One Earth Solar Farm

**Draft Statement of Common Ground with Newark and
Sherwood District Council**

EN010159/APP/8.6.1

July-August 2025

Drawing file: published-documents / EN010159-000303-6.20 Environmental Statement Volume 3 - Figures 11.10 Representative Viewpoint Locations.pdf

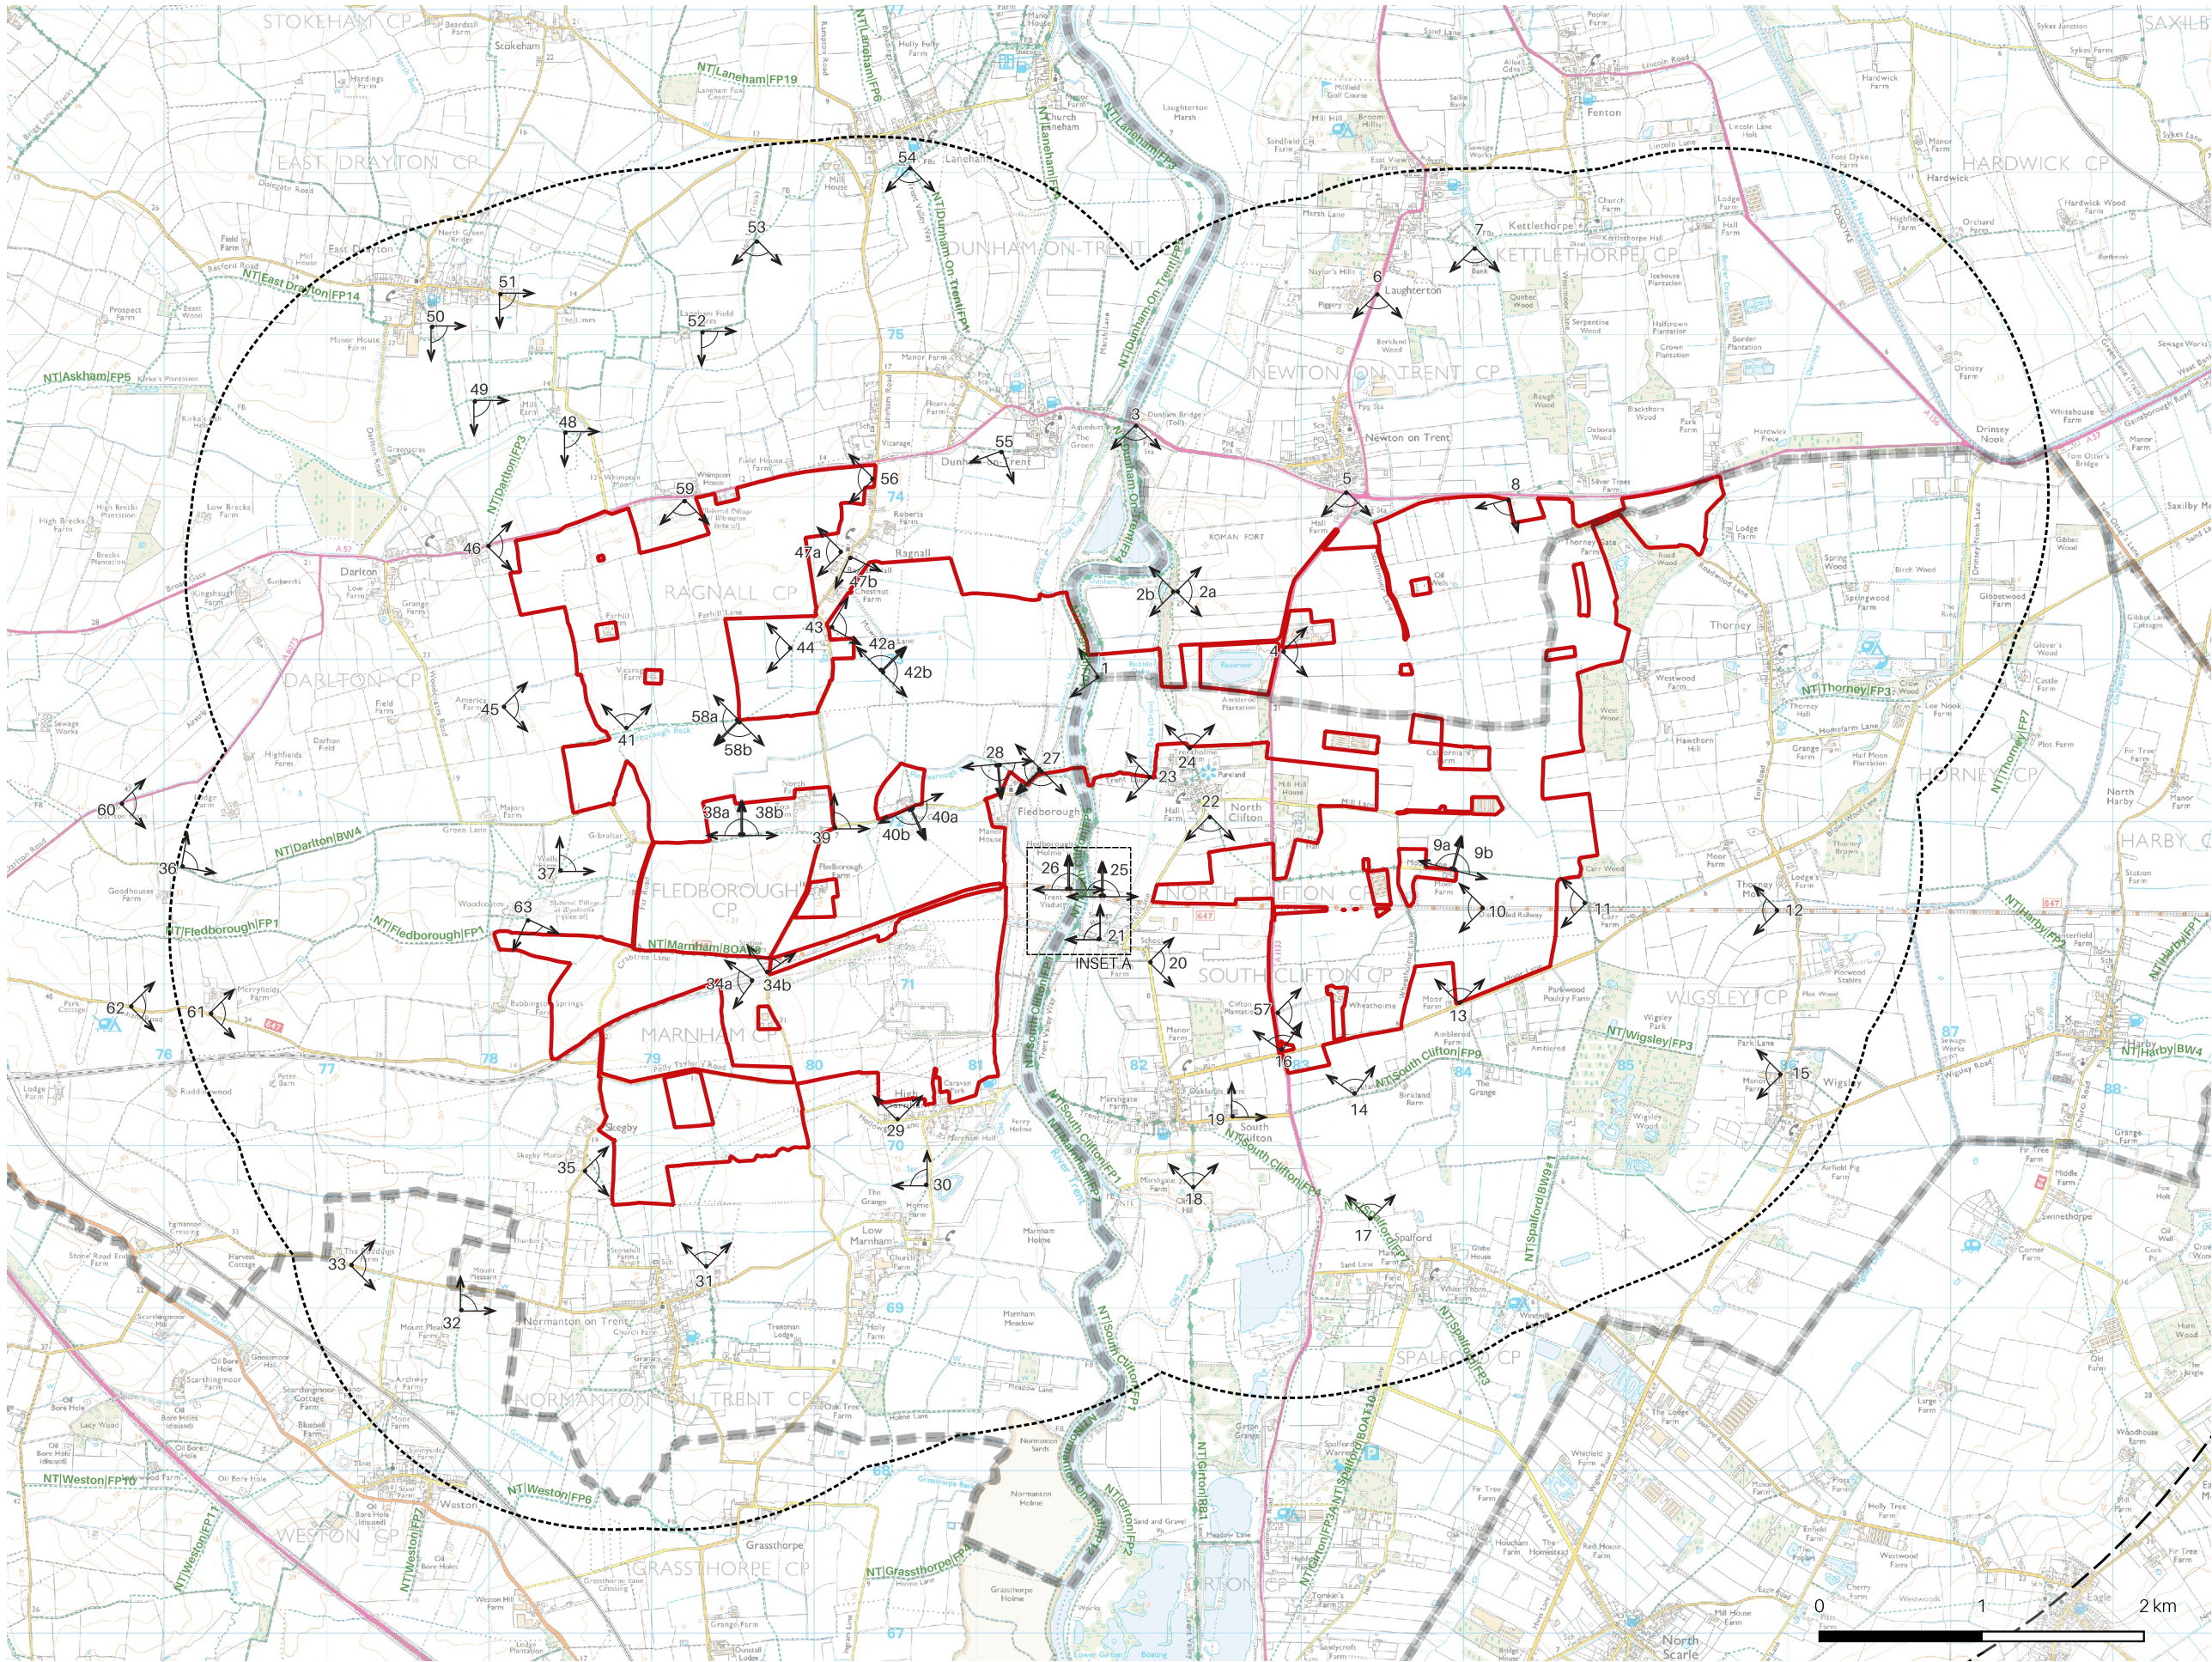
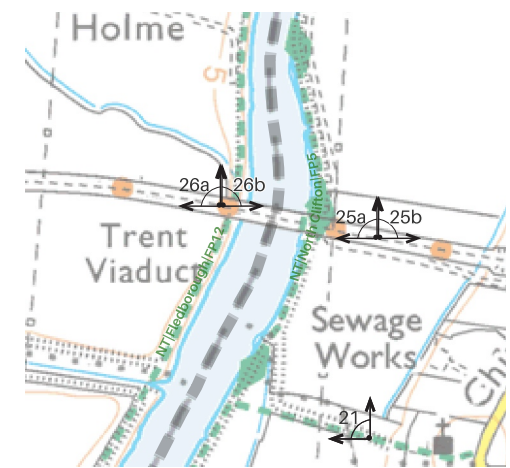
| 04-05 | Scope of representative viewpoints | The location of some of the representative viewpoints were questioned and additional viewpoints | The scope of representative viewpoints is agreed. | Agreed |

| | | <p>were suggested following review of the PEIR.</p> <p>No further comments or concerns on the scope of representative viewpoints have been raised.</p> | <p>The scope of representative viewpoints was updated in the LVIA ES Chapter to include for the suggested additions and refinements.</p> | |
